WEST SUSSEX COUNTY COUNCIL CONSULTATION

TO:	Arun District Council FAO: Miss K Welch
FROM:	WSCC - Highways Authority
DATE:	4 April 2022
LOCATION:	166 Littlehampton Road, Ferring, BN12 6PH
SUBJECT:	FG/36/22/HH Two storey side extension, single storey front extension and new entrance and new vehicular access.
DATE OF SITE VISIT:	n/a
RECOMMENDATION:	More Informationl
S106 CONTRIBUTION TOTAL:	n/a

Drawing Title:
Site Plan and Location Plan

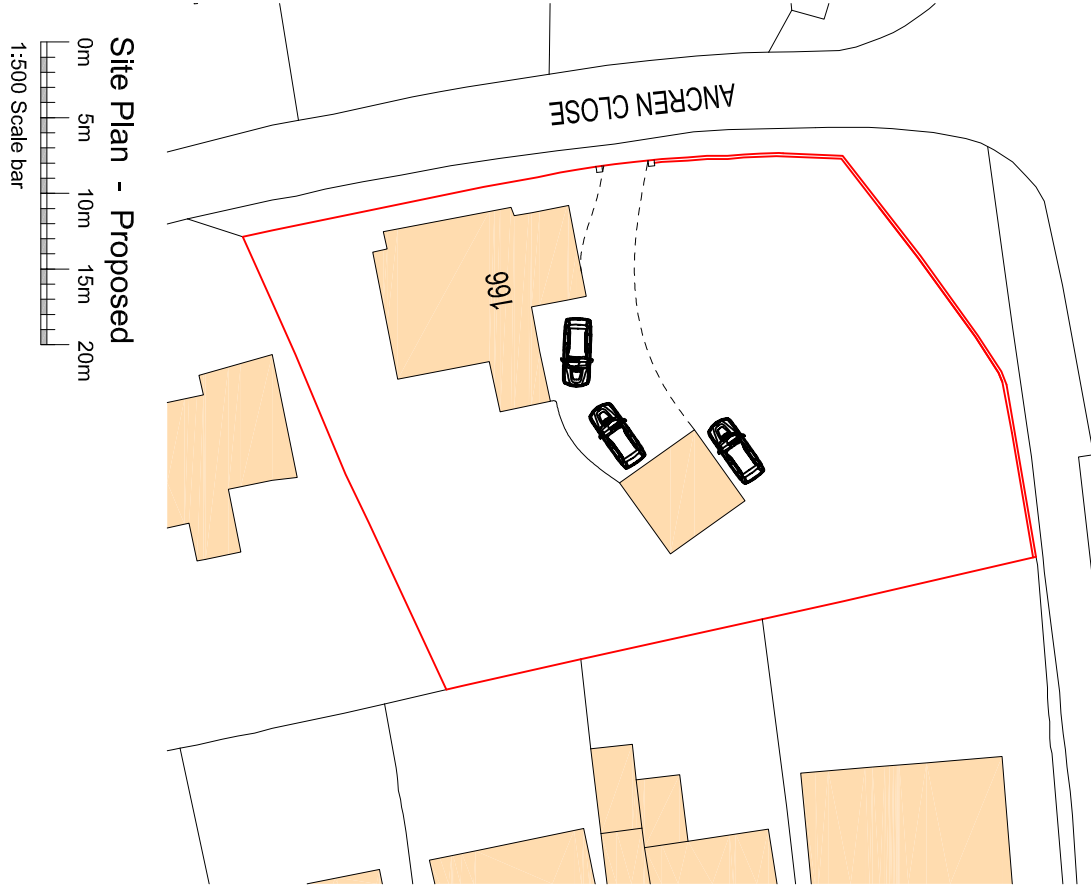
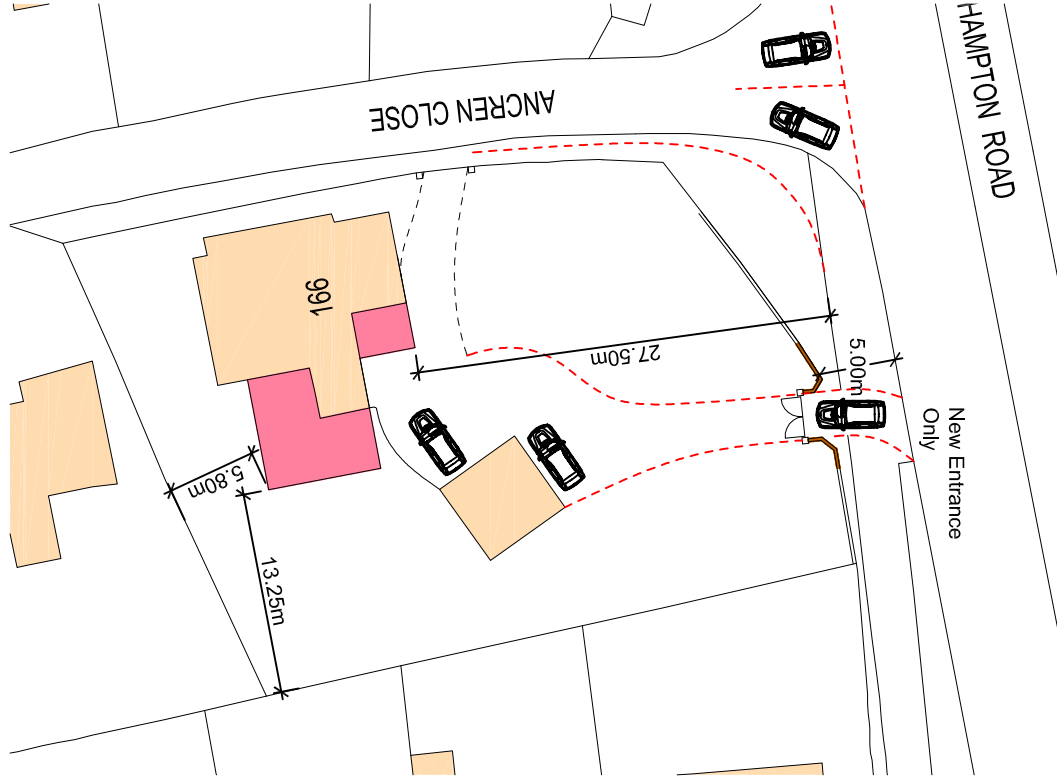
A new access is proposed onto A259 which is subject to a 50 mph speed limit at this point.

It is noted that the plans detail this access as being 'In Only'. There would be no way to formally control that so therefore it has to be considered that the access could be used for movements onto A259 also.

While visibility splays have not been demonstrated the Local Highway Authority is satisfied that in principle suitable visibility is achievable using the extent of public highway available.

However it seems that the access will adjoin A259 at a point that is currently occupied by a bus stopping point / cage.

The applicant should demonstrate this bus stopping location / cage on the submitted plans. Will the us stopping point / cage be moved? Has the applicant contacted the bus operator to discuss the relocation of the bus stopping point / cage? Has the applicant contacted WSCC Highways with regard to relocating the bus stopping point / cage?

The Local Highways Authority would request the applicant provide more justification for the requirements of the access. The dwelling seems to be served adequately via Ancren Close.

If the bus cage / stopping point is to remain, the applicant should address concerns that a stopping bus will fully obstruct visibility for a vehicle making use of the proposed access, both in and out.
